KITTTITAS COUNTY COMMUNITY DEVELOPMENT SERVICES

RE: Burr Short Plat (SP-11-00002)

The Kittitas County Community Development Services Department has determined that the Burr Short Plat (SP-11-00002) is a complete application and hereby grants *conditional preliminary approval* subject to the following conditions:

**BURR SHORT PLAT**  
A PORTION OF THE NORTH 1/2 OF THE NORTHWEST 1/4 OF SECTION 9,  
TOWNSHIP 18 NORTH, RANGE 17 EAST, W.M.,  
KITITITAS COUNTY, WASHINGTON

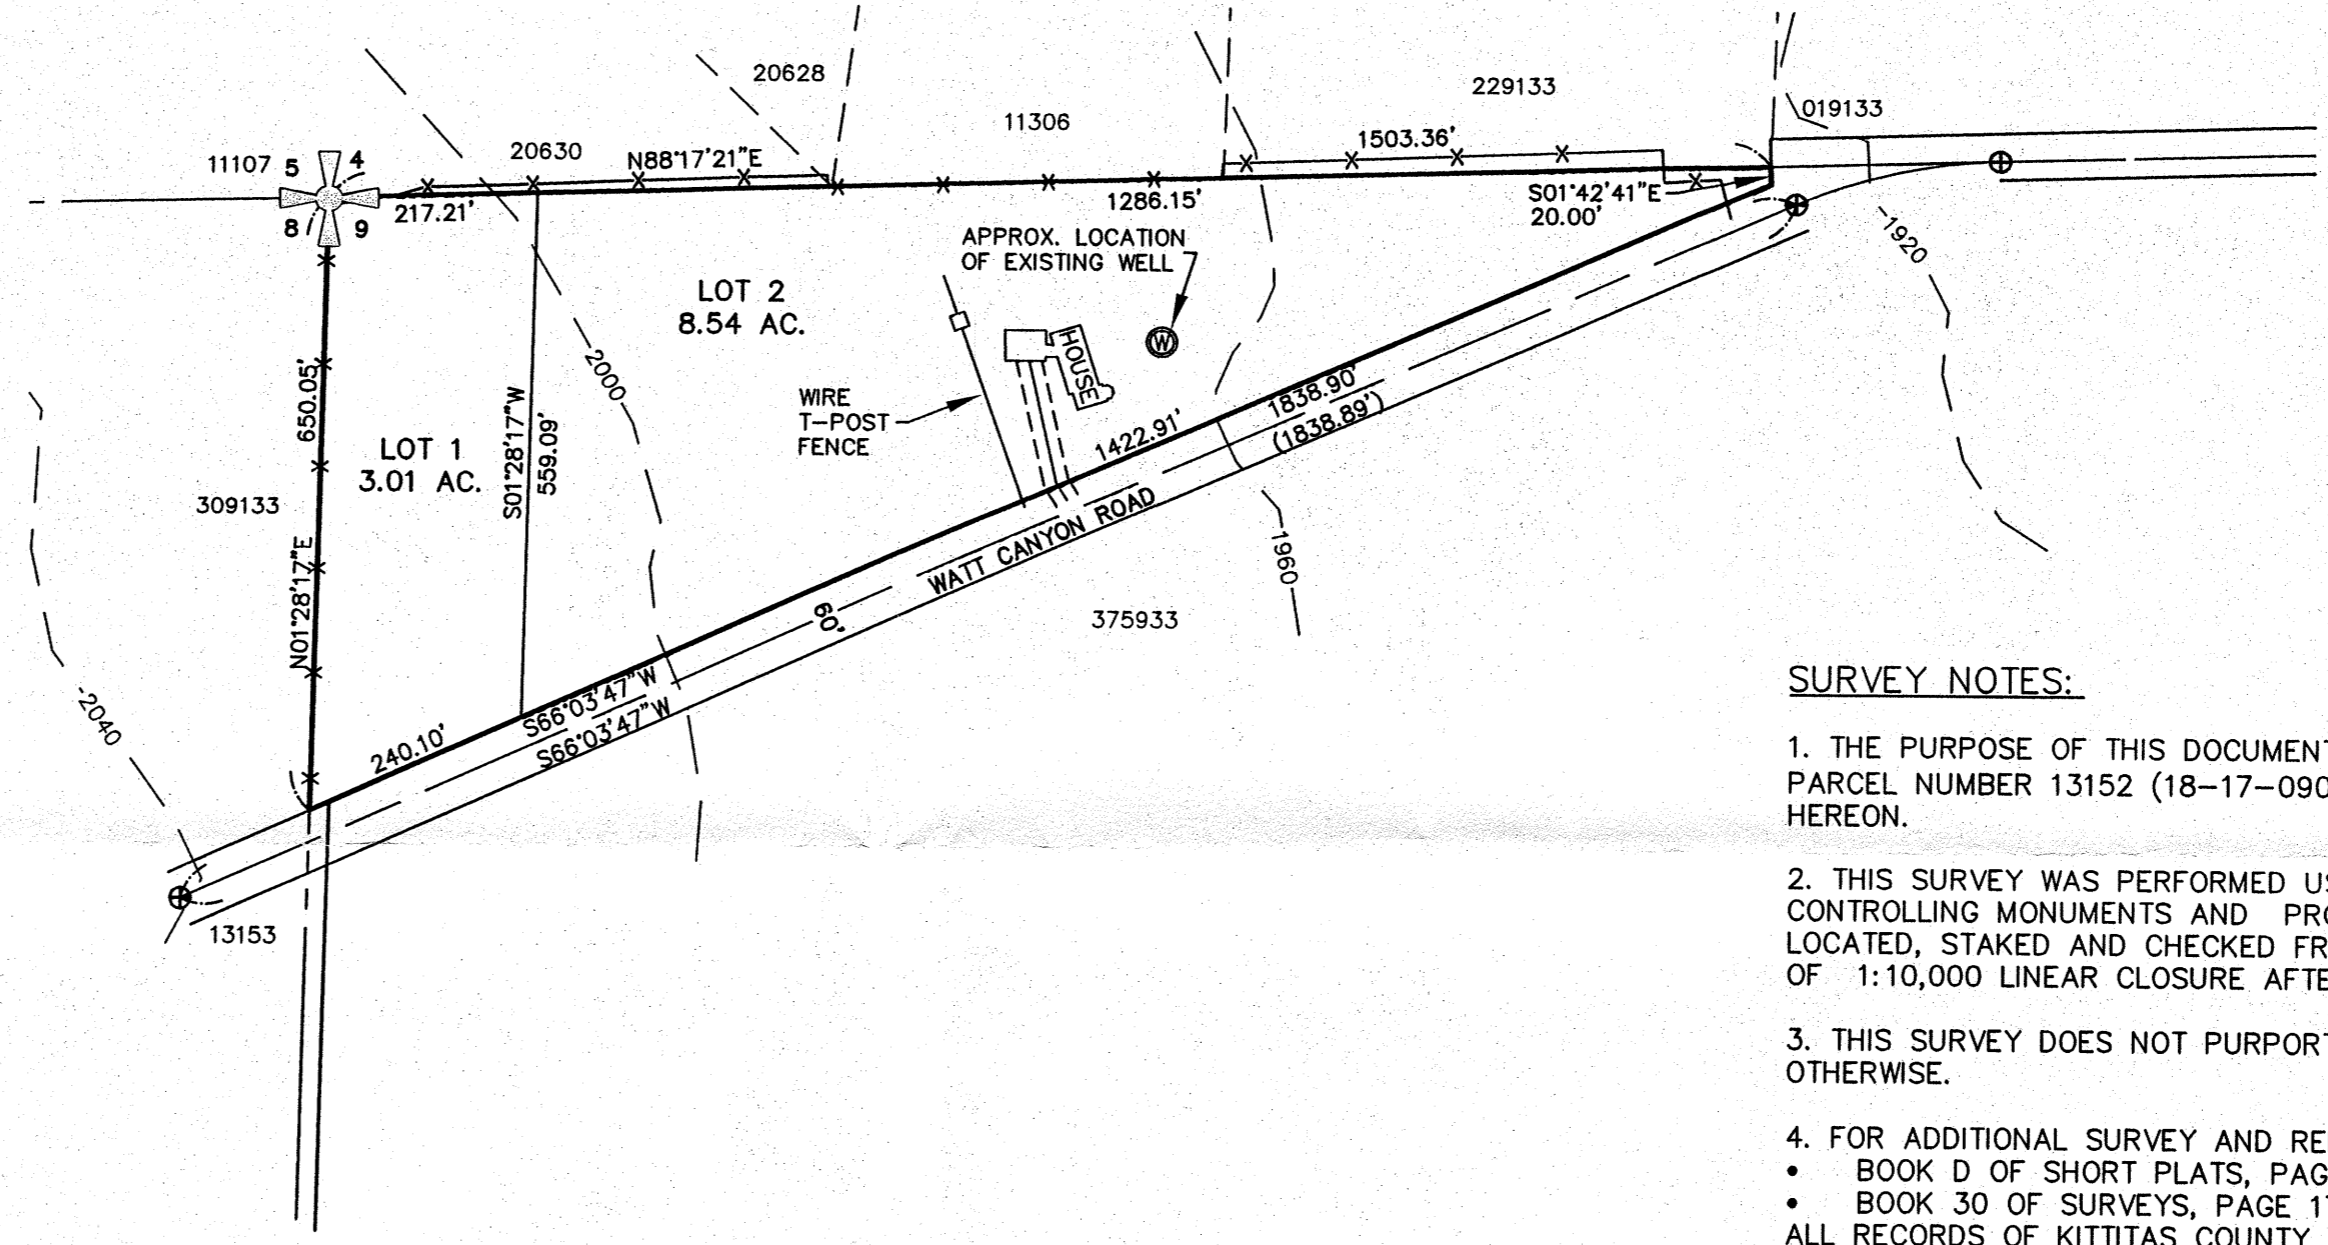
1. Both sheets of the final mylars shall reflect short plat number SP-11-00002 and an accurate legal description shall be shown on the face of the final plat.

6. A statement regarding the contemplated sewage disposal, water supply, and drainage improvements for the proposed subdivision shall be reflected on the final mylars.

8. Individual wells are required to have a 50 foot setback from neighboring property lines (KCC 17A.08.025). Please see the comments from Kittitas County Public Health Department for further information and requirements.

13. The addresses shall be clearly visible from both directions at the County Road for all properties.
14. The Fire Department access road shall be capable of supporting 75,000 lbs in all weather, be 20' wide, provide 13'6" vertical clearance and provide for adequate turn-around for fire department apparatus.
